From: Paul Cann <Paul.Cann@arun.gov.uk>
Sent: 09 October 2020 14:54
To: Planning.Responses <Planning.Responses@arun.gov.uk>
Subject: RE: Planning Consultation on: BR/190/20/OUT

Engineers Comments Regarding Surface Water Drainage

Application No: BR/190/20/OUT
Registered: 2nd September 2020
Site Address: 26 Burnham Avenue Bognor Regis PO21 2JU

Description of Works: Outline application with all matters reserved for 10 No. new dwellings consisting of 1 No. 1 bed property, 8 No. 2 bed properties & 1 No. 4 bed property with associated services, landscaping, car parking & amenity (resubmission following BR/49/19/OUT).

SITE PLAN (PROPOSED) 1:200

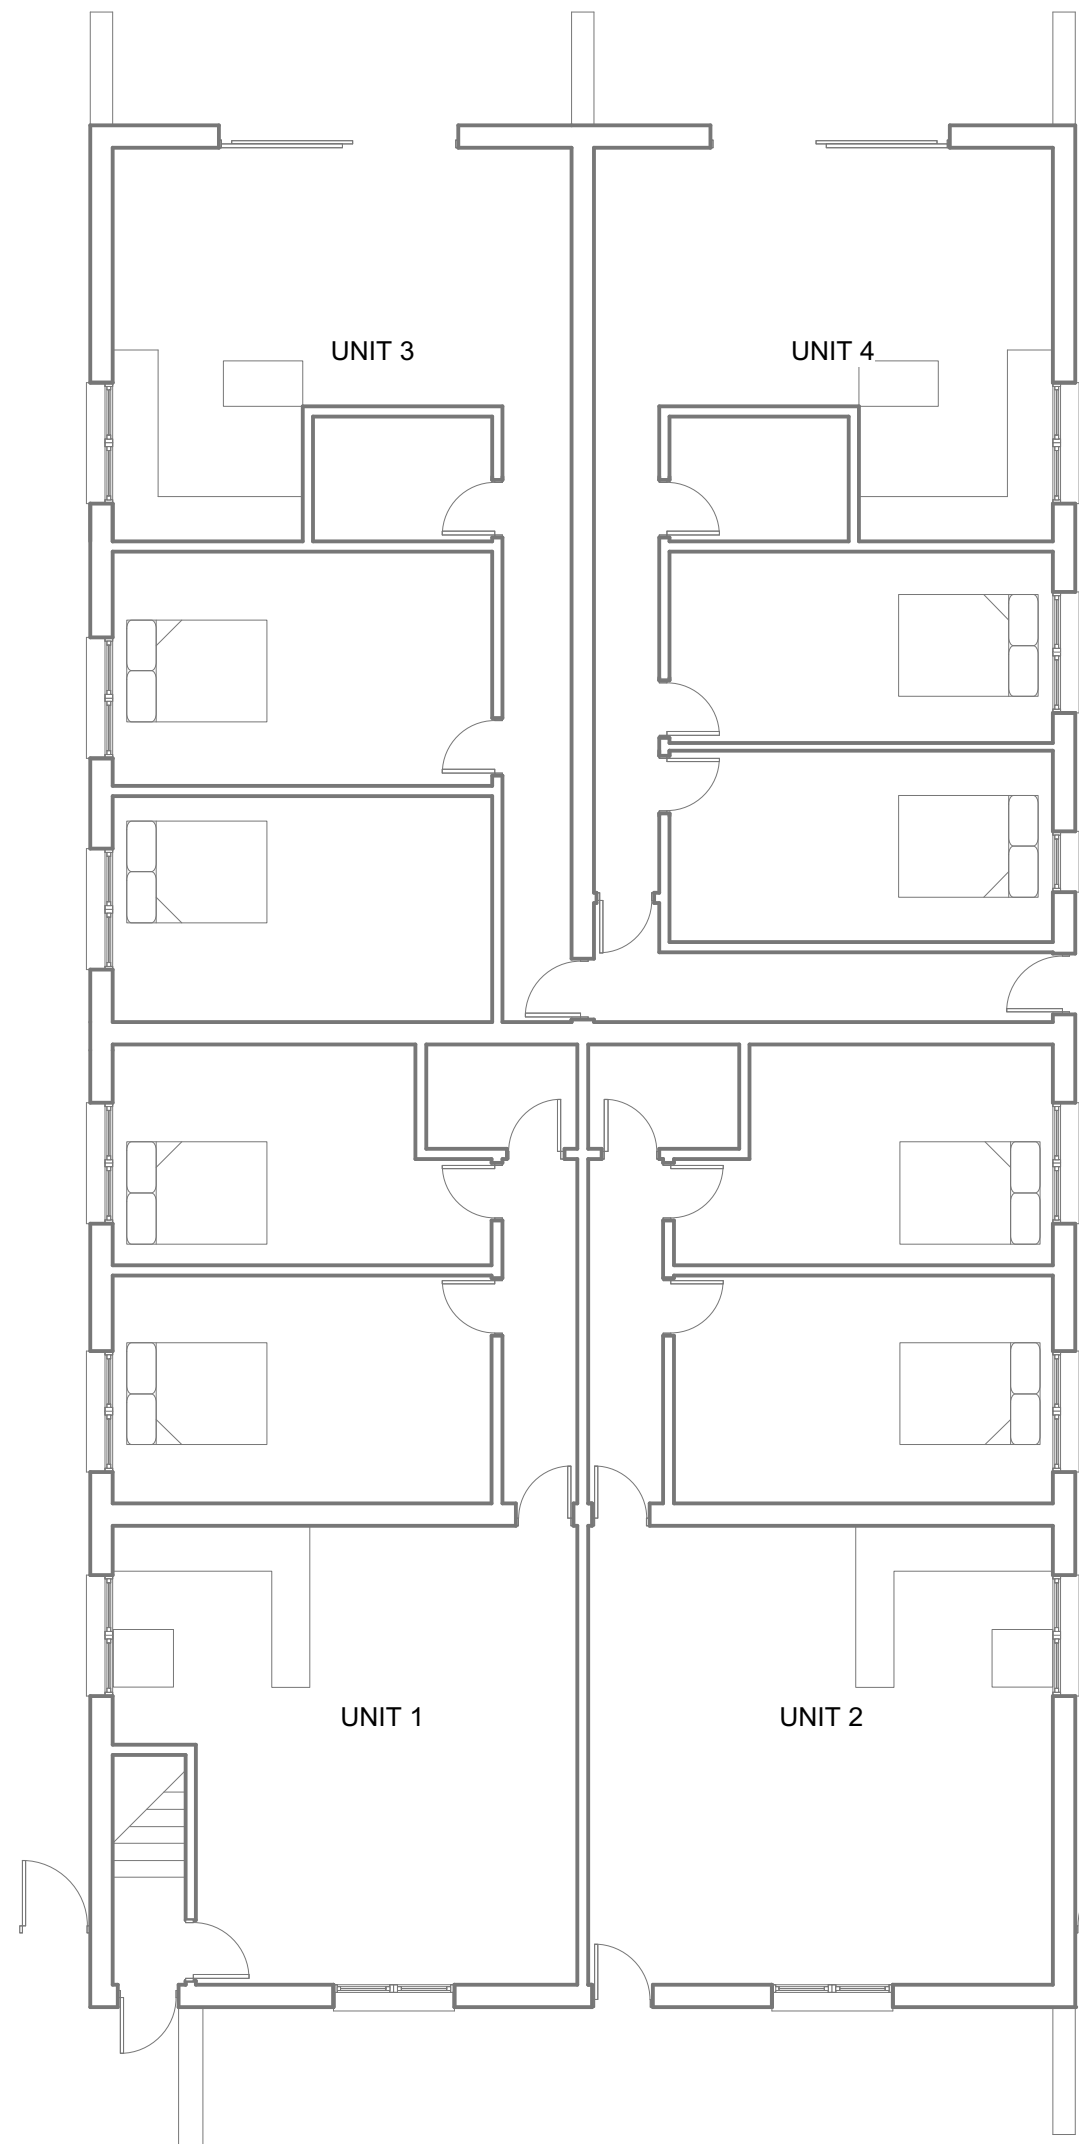
Groundwater levels are expected to be reasonably high. We would expect to see permeable paving to be incorporated for not only the car parking areas but the driveway also, not only provide a water storage/infiltration structure but to aid water treatment.
